Rezoning Transportation Analysis

Petition Number: #2022-087

Date	Description
11-28-22	First Review (TM)
12-22-22	Second Review (DR)

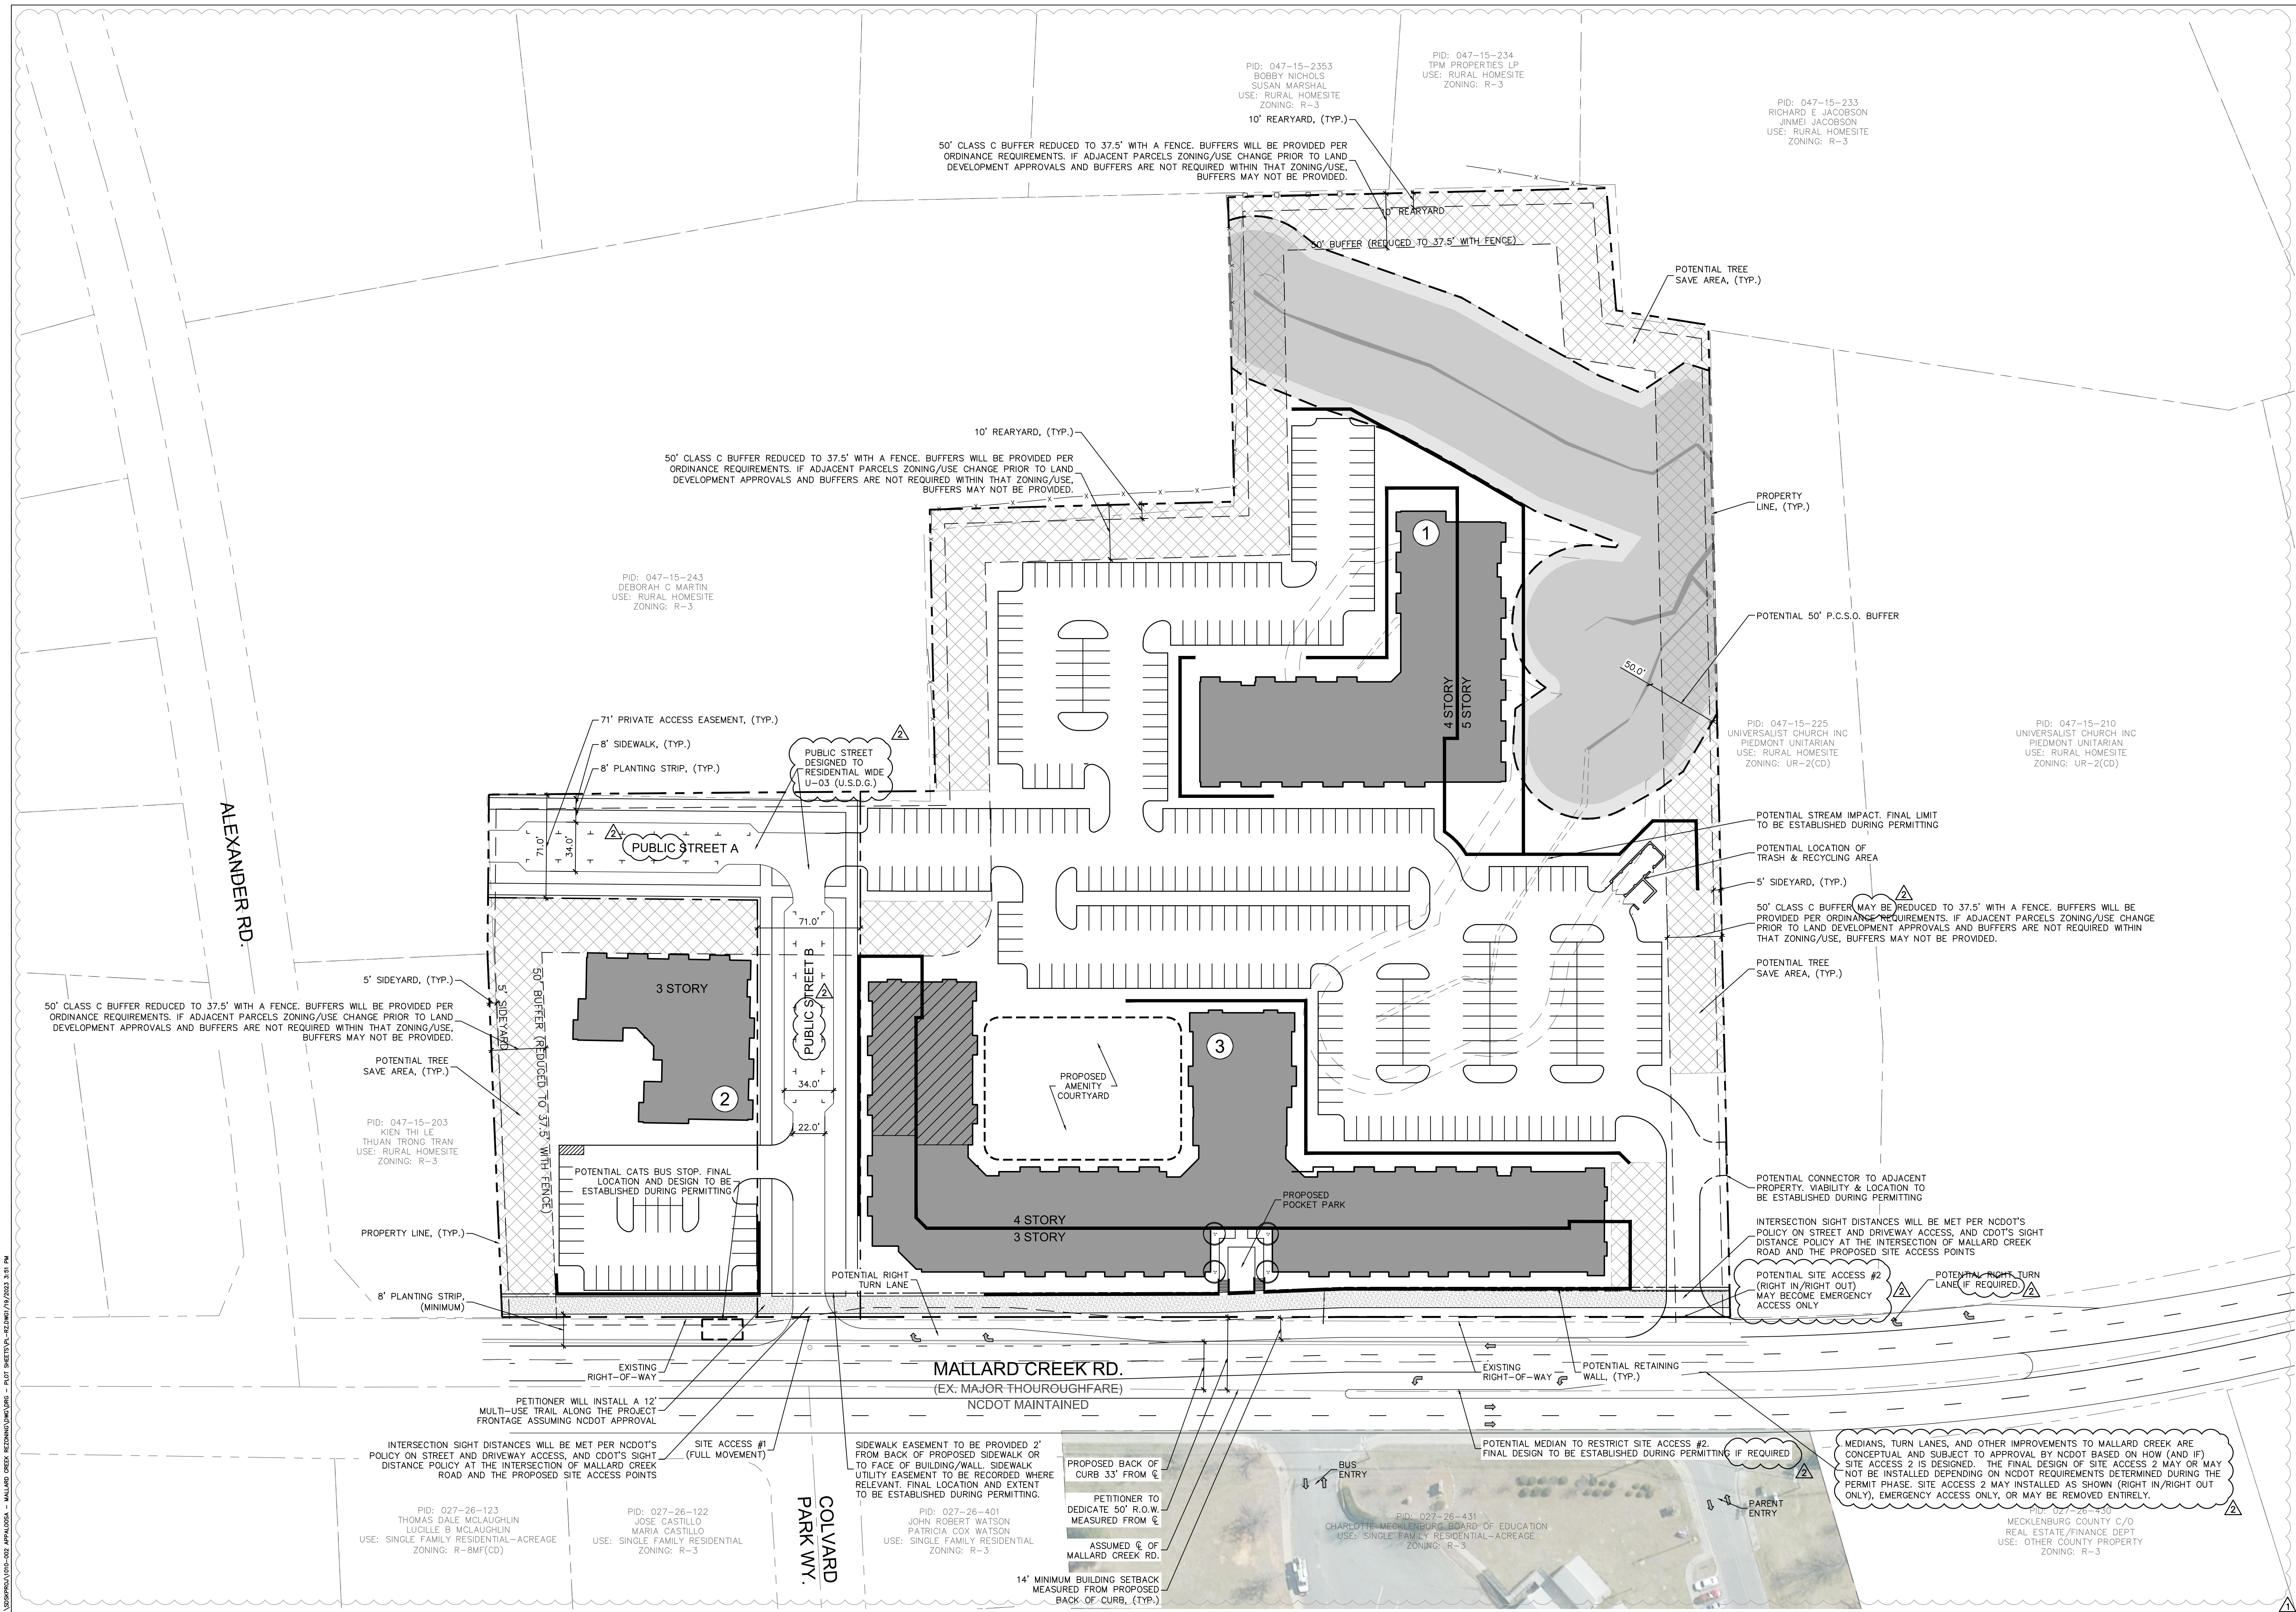
Clarifying comment from 12/22/2022: Private Street A and Private Street B will both need to be public streets per coordination with subdivision. Remove all references to private access easements for Private Streets A and B.

- New comment from 12/22/2022:** Modify median to ensure full movement for development adjacent can be retained from parcels 04715225 and 04715210. What is being proposed will create a change of access for the development adjacent to property.

13. **New comment from 12/22/2022:** Either remove conditional note or add as approved by NCDOT/CDOT at the end.

14. **New comment from 12/22/2022:** Remove word "potential" on callout for right turn lanes at site accesses. This is an NCDOT requirement. Add conditional note regarding right turn lanes at each site access. Label and dimension right turn lanes.

15. **New comment from 12/22/2022:** Remove "assuming NCDOT approval" on callout for 12-foot multi-use trail.
